**Subject: Evergreen Ridge PUD, Rockberry Loop (LPF-19-00001) Final Long Plat – Second Review and Request for Additional Information**

**RE:** Rockberry Final Plat

Public Works has reviewed the final plat submitted for Rockberry Loop (LPF-19-00001). Our comments appear below for your consideration.

DWN BY	DATE	JOB NO.
D.L.P./G.W.	04/2019	16078
CHKD BY	SCALE	SHEET
D.L.P.	1" = 100'	2 OF 6

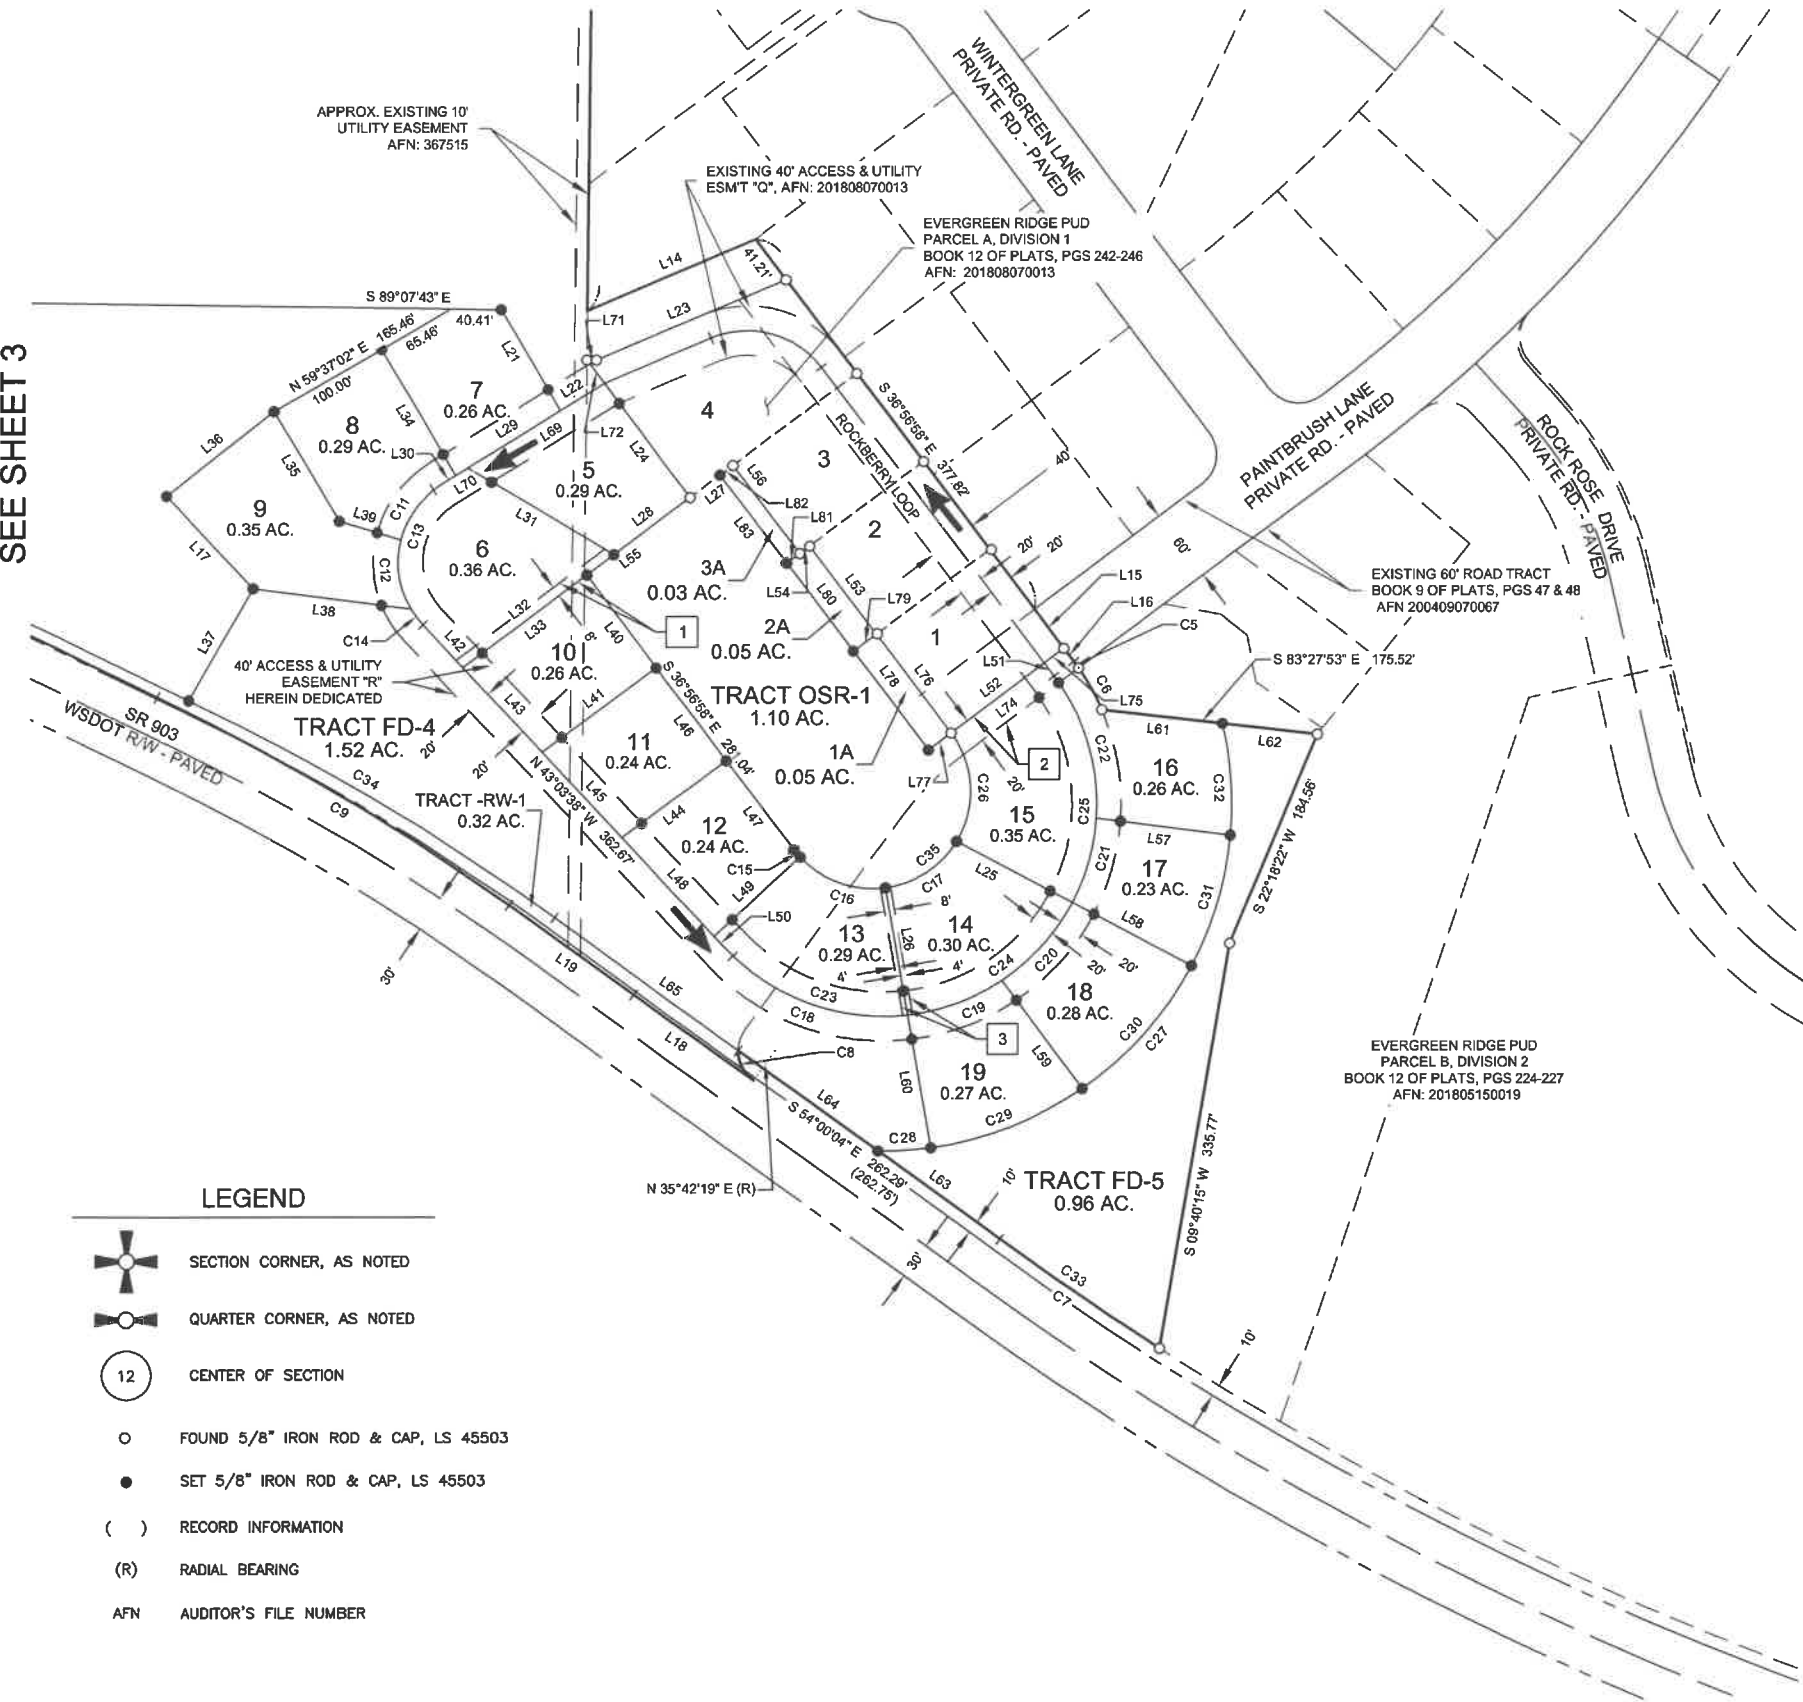
1. Kittitas County Road Standards do not contemplate a “one way” road. The proposed right of way width of 40 feet appears sufficient in the absence of a standard. The road shall be a minimum width of 20 feet with one foot shoulders.
2. Prior to final approval of any land use development activity, a performance guarantee is required.
3. A stormwater management plan meeting the current requirements of the Eastern Washington Stormwater Manual (WA DOE) is required prior to any land use development activity.
4. “Double O Road” easement width and road standard shall be resolved to the satisfaction of Kittitas County Department of Public Works prior to any land use development activity.
